DRB CASE ACTION LOG

DRB Application No.:03-00052 (P&F)	Project # 1002380
Project Name: ALVARADO GARDENS UNIT 2	EPC Application No.:
Agent: Surveys Southwest	Phone No.: <u>998-0303</u>

Subject: Alvarado Gardens, Unit 2 /Plat Approval

PLAT OF
LOTS 39-A, 39-B & 39-C
ALVARADO GARDENS ADDITION, UNIT 2
SECTION 1, T. 10 N., R. 2 E., N.M.P.M.
CITY OF ALBUQUERQUE
BERNALILLO COUNTY, NEW MEXICO
JANUARY 2003
SHEET 2 OF 2

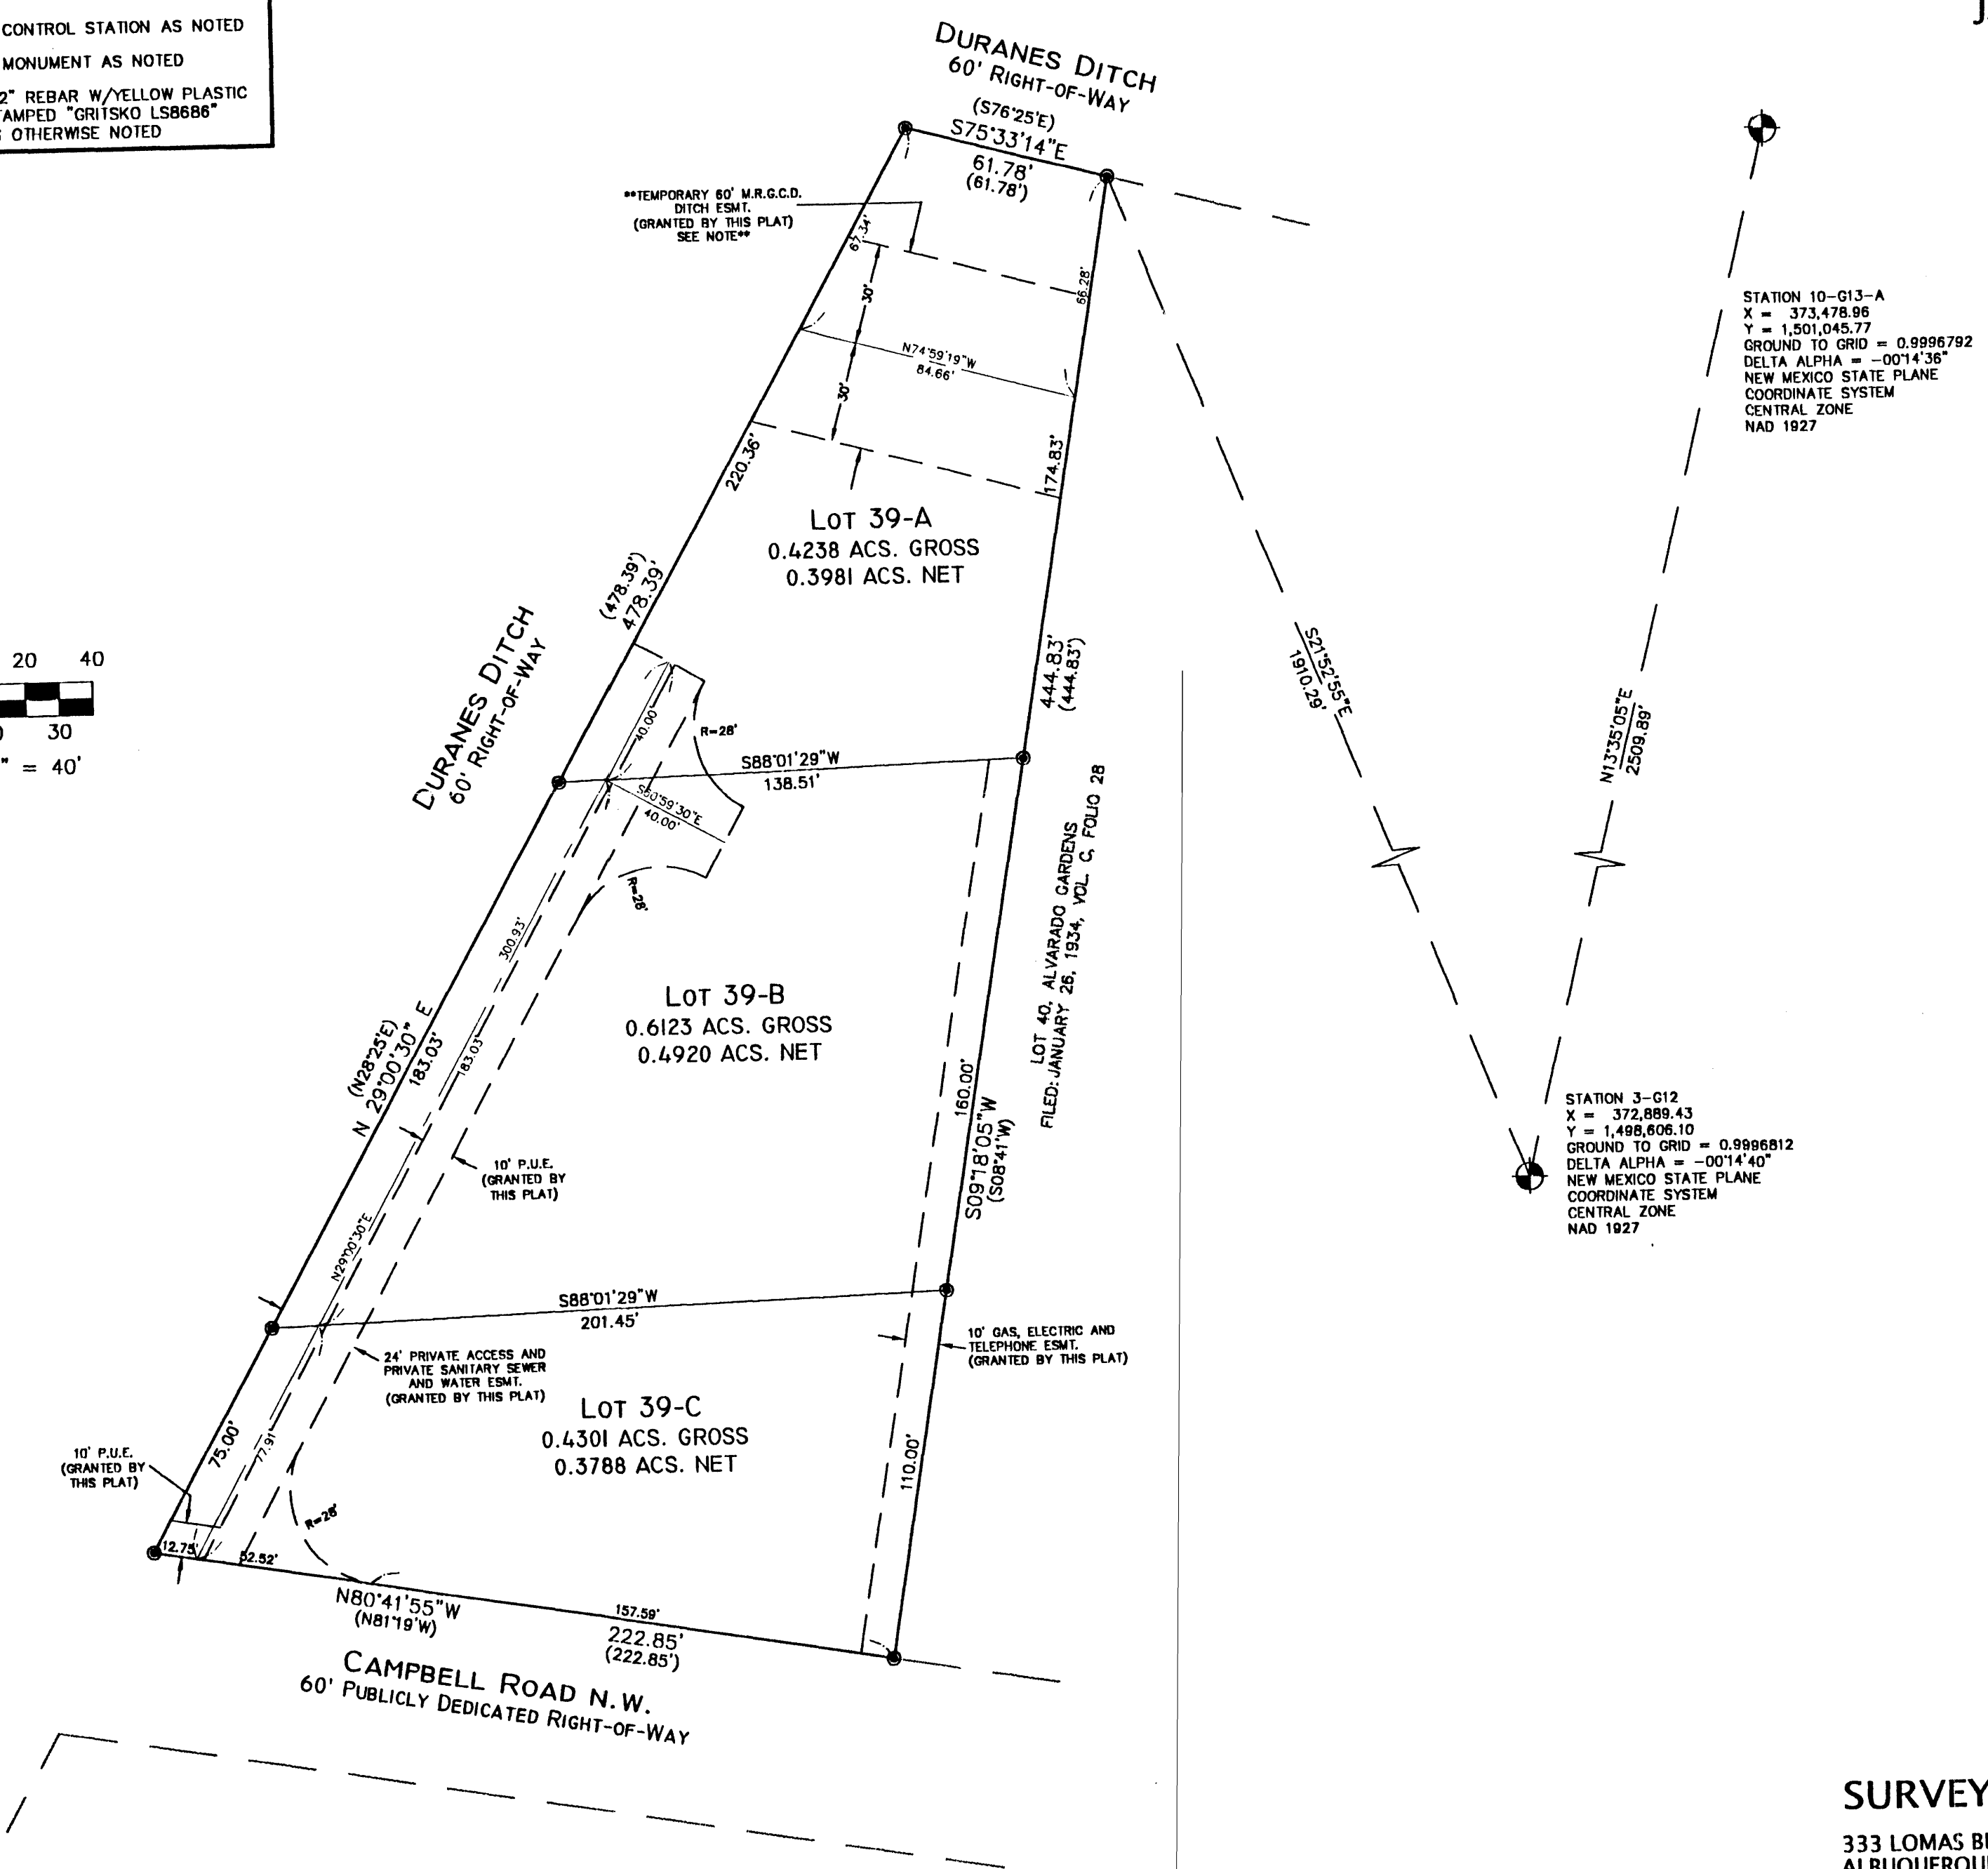
- UTILITIES: _____
 -Label Private Easements to include Water/Sewer Service lines.
 -Label P.U.E on access easement.

- CITY ENGINEER / AMAFCA: _____
 MRGCD signature

- PARKS / CIP: _____
 C.I.L for park ded. fee
